Rezoning Transportation Analysis

Petition Number: #2022-168

Revision Log:

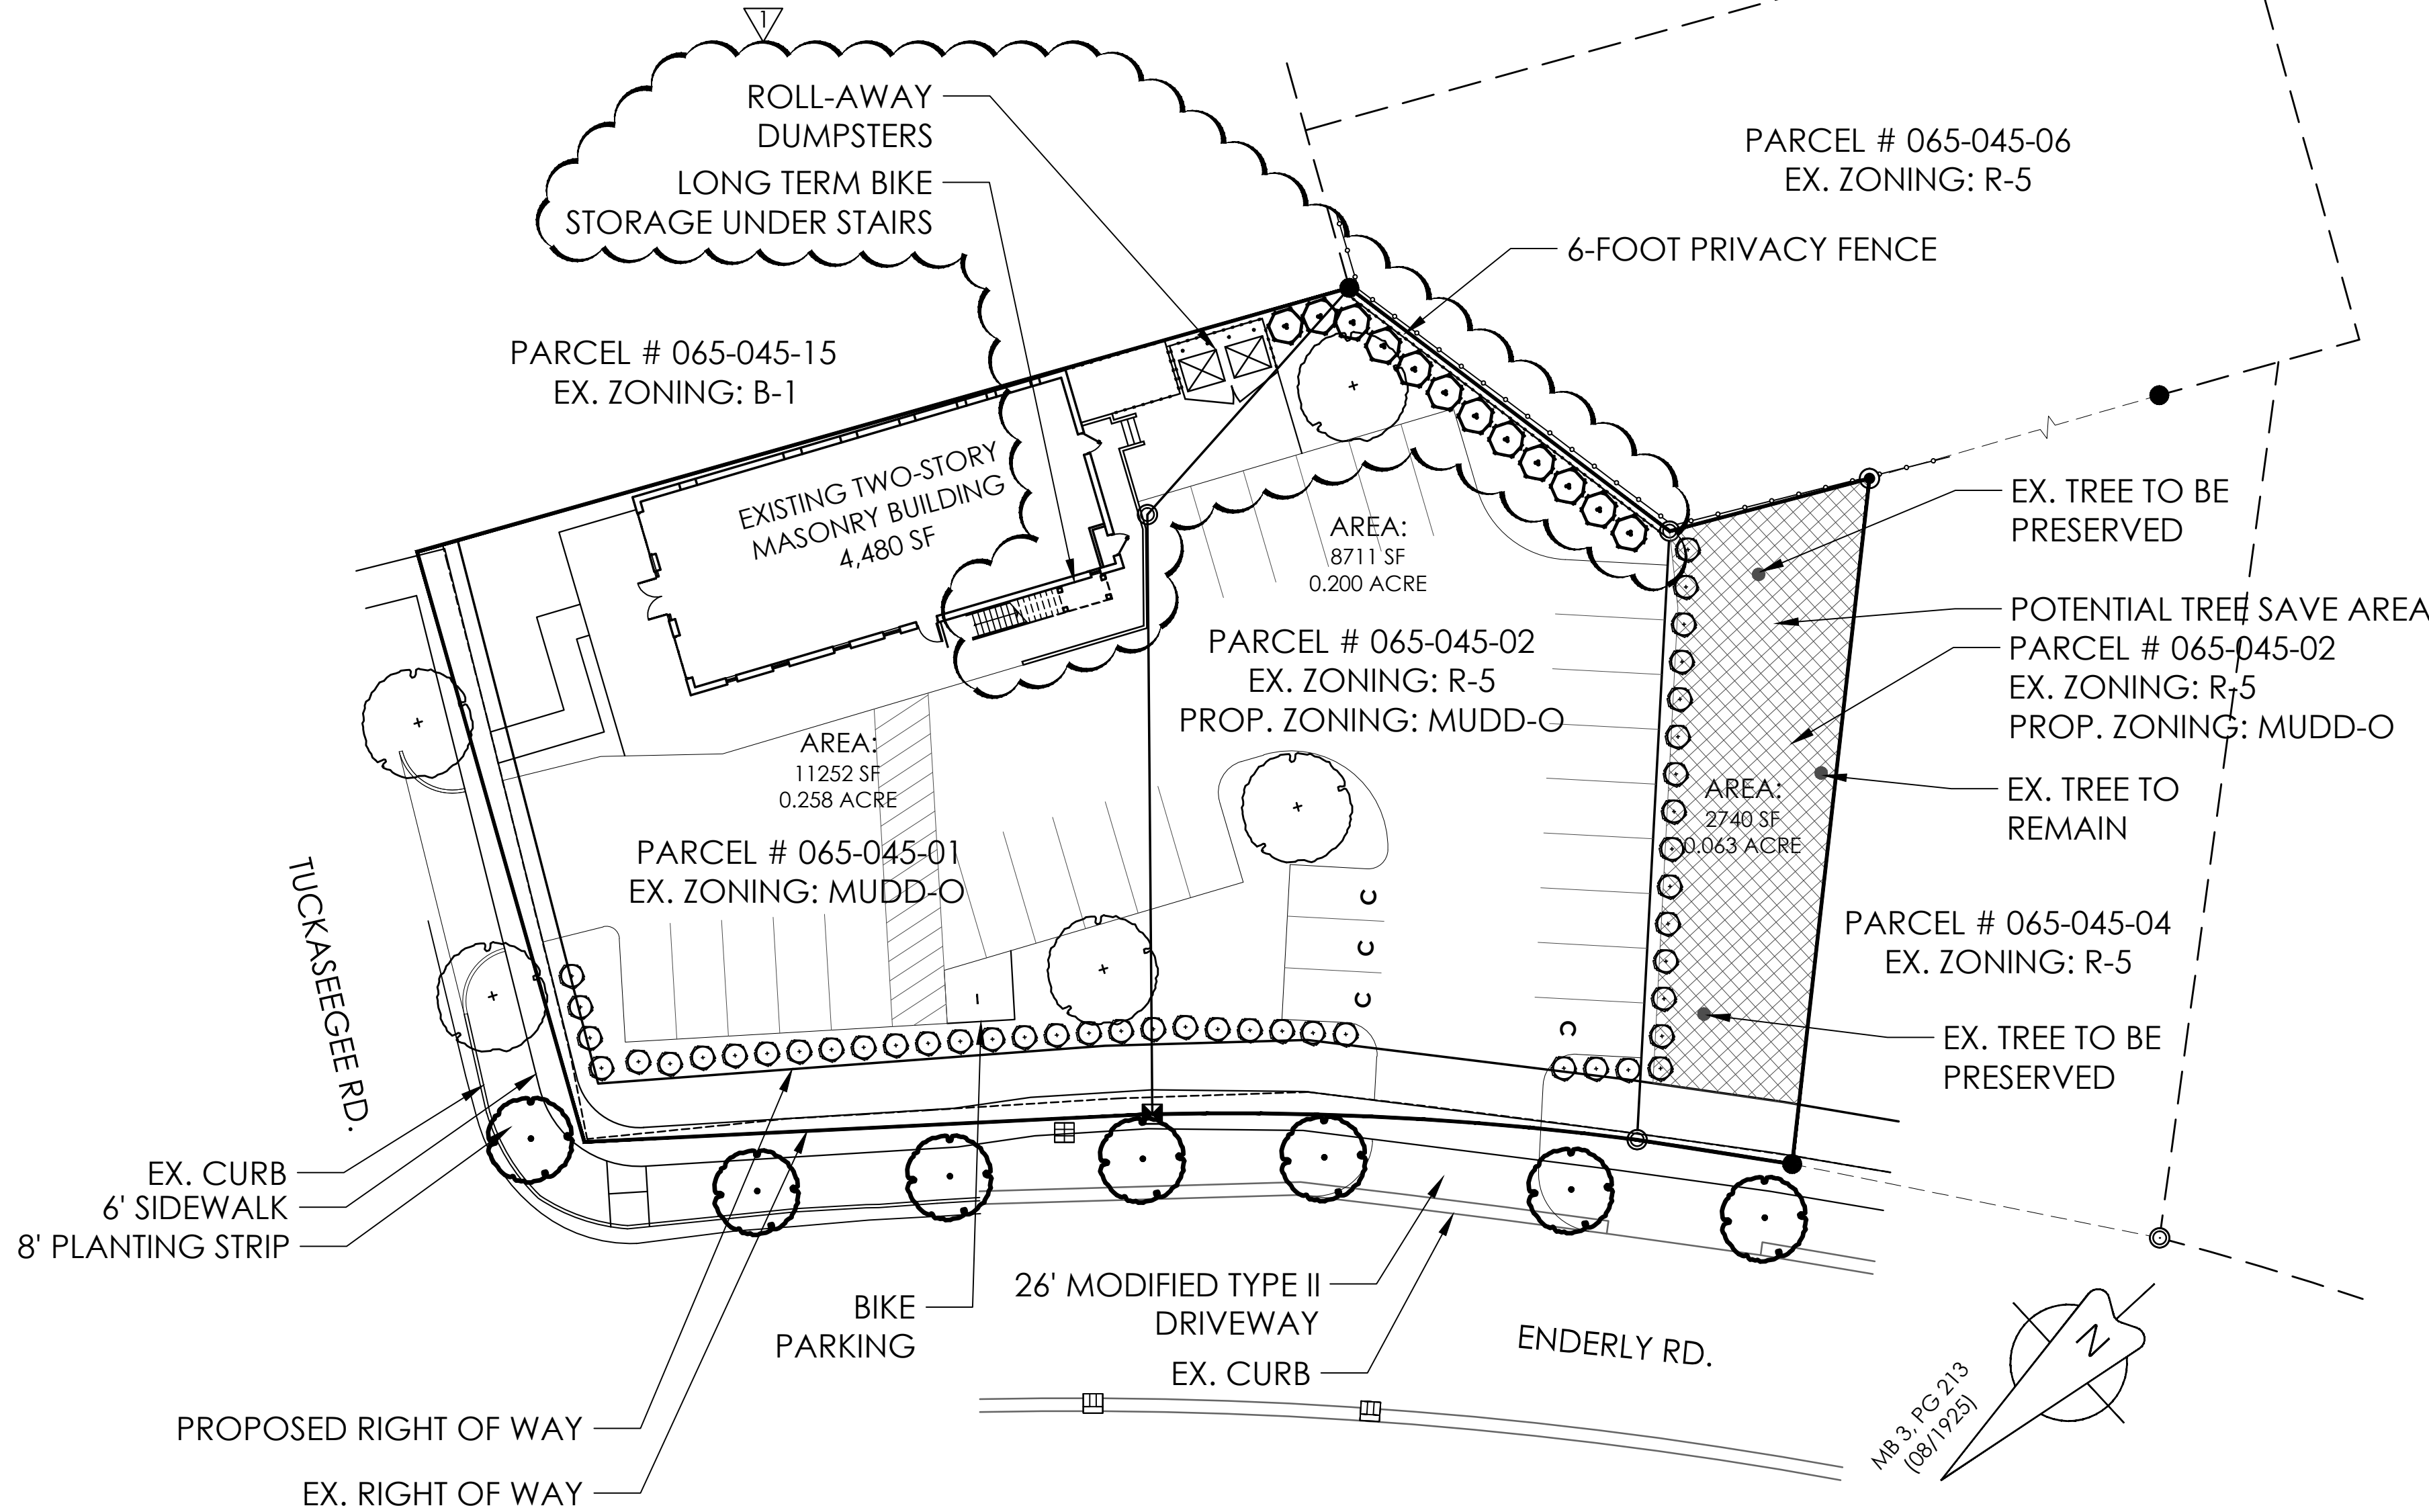
a. ~~**Outstanding Comment from 02-22-23: Tuckaseegee Road:** Location of curb and gutter to be moved to 27 feet from roadway centerline to accommodate the Charlotte Streets Map with a roadway typical section of a 2+ Avenue, Buffered/Separated Bike Lanes. Show future curb line on site plan and dimension planting strip and sidewalk from the future back of curb location.~~

~~**Outstanding Comment from 02-22-23:** Label and dimension the curb and gutter from the centerline for each road on the site plan.~~

3. ~~Revise site plan to commit to dedicate 40 feet of right of way from the Tuckaseegee Road centerline. The site plan shall label and dimension the right of way from the road centerline.~~

4. ~~Revise site plan to commit to dedicate 36 feet of right of way from the Enderly Road centerline. The site plan shall label and dimension the right of way from the road centerline.~~

5. ~~**CDOT REQUEST:** that site plan and conditional note(s) revisions are made to commit to construct an 8-foot planting strip, and 8-foot sidewalk on Tuckaseegee Road to match the overall city plan for this street section per Charlotte Streets Map. The site plan shall label and dimension both items from the future back of curb and gutter. The wider sidewalk also meets the Charlotte WALKS Policy~~

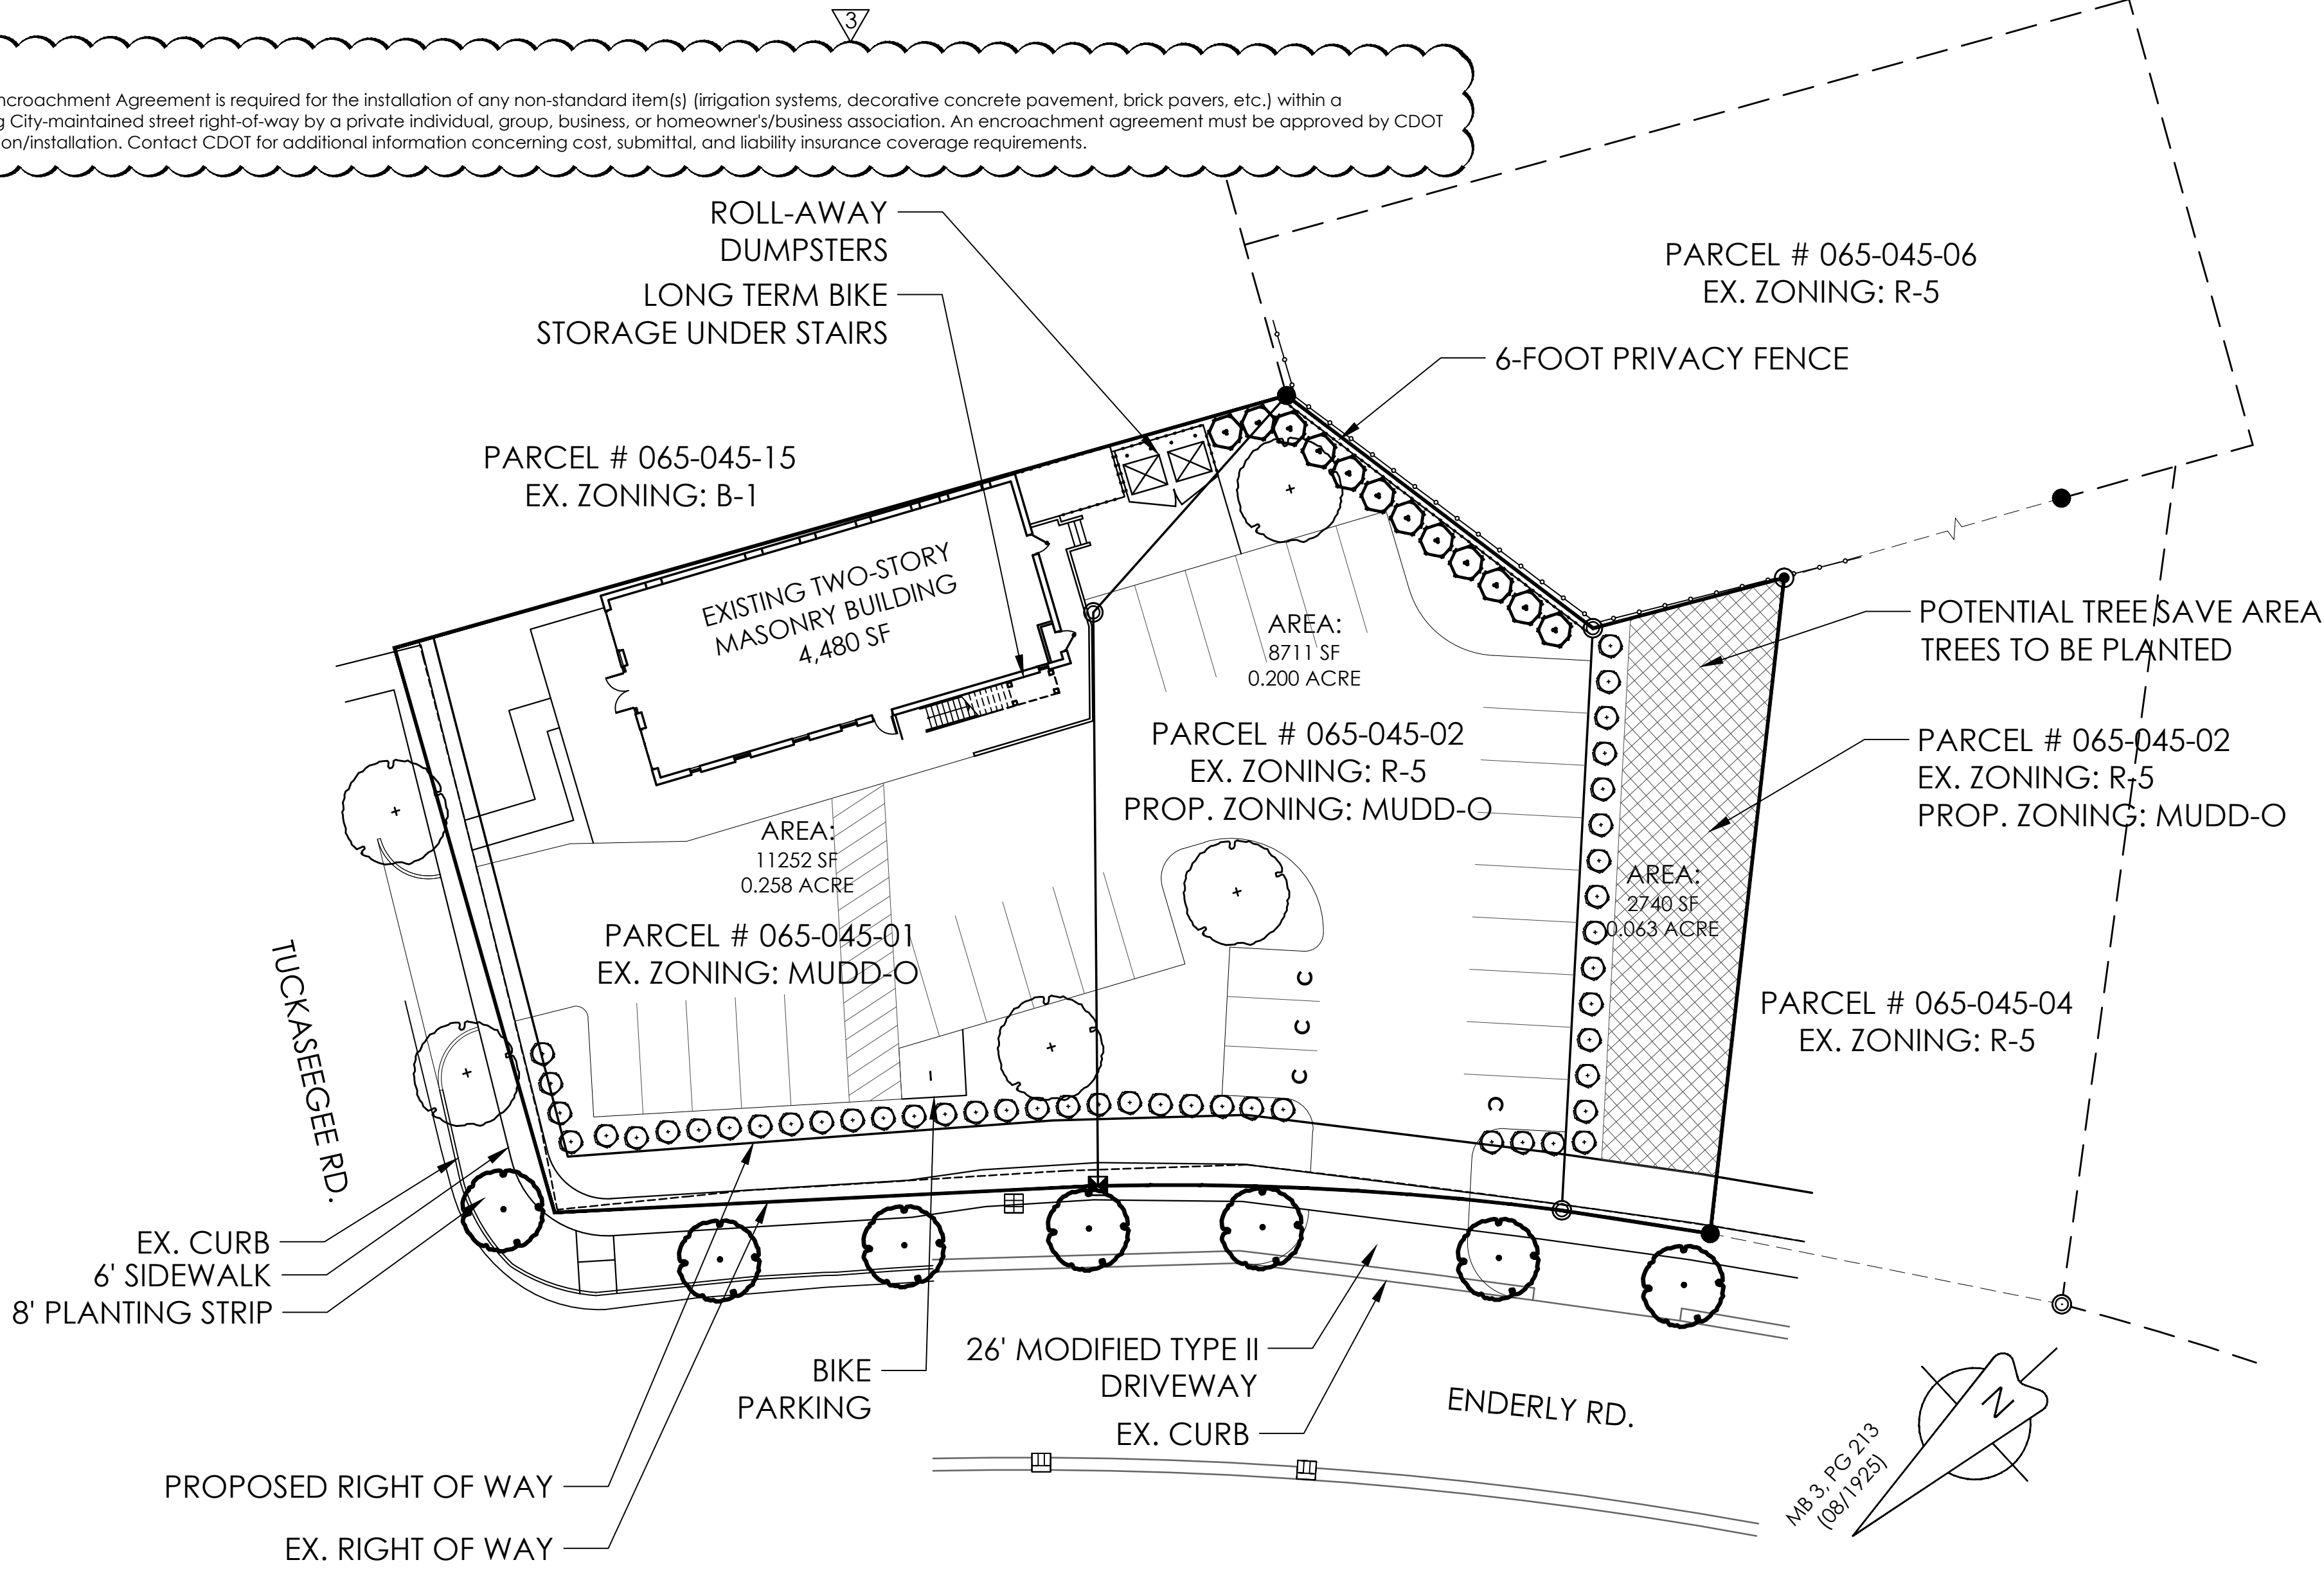
- ~~6. **Outstanding Comment from 02-22-23:** Add a conditional note specifying "A Right of Way Encroachment Agreement is required for the installation of any non-standard item(s) (irrigation systems, decorative concrete pavement, brick pavers, etc.) within a proposed/existing City-maintained street right-of-way by a private individual, group, business, or homeowner's/business association. An encroachment agreement must be approved by CDOT prior to construction/installation. Contact CDOT for additional information concerning cost, submittal, and liability insurance coverage requirements."~~

- ~~7. Add a conditional note specifying "the Petitioner shall dedicate and convey in fee simple all rights-of-way to the City before the site's first building certificate of occupancy is issued. CDOT requests rights-of-way set at 2' behind back of sidewalk where feasible."~~

- ~~8. Revise conditional note specifying "All transportation improvements will be approved and constructed before the site's first building certificate of occupancy is issued. The petitioner may phase transportation improvements if said improvements and phasing are explicitly described in site plan notes."~~

- FROM THE ISSUANCE OF A CERTIFICATE OF OCCUPANCY FOR THE BUILDING
8. ALL TRANSPORTATION IMPROVEMENTS SHALL BE APPROVED AND CONSTRUCTED PRIOR TO THE ISSUANCE OF A CERTIFICATE OF OCCUPANCY FOR THE BUILDING
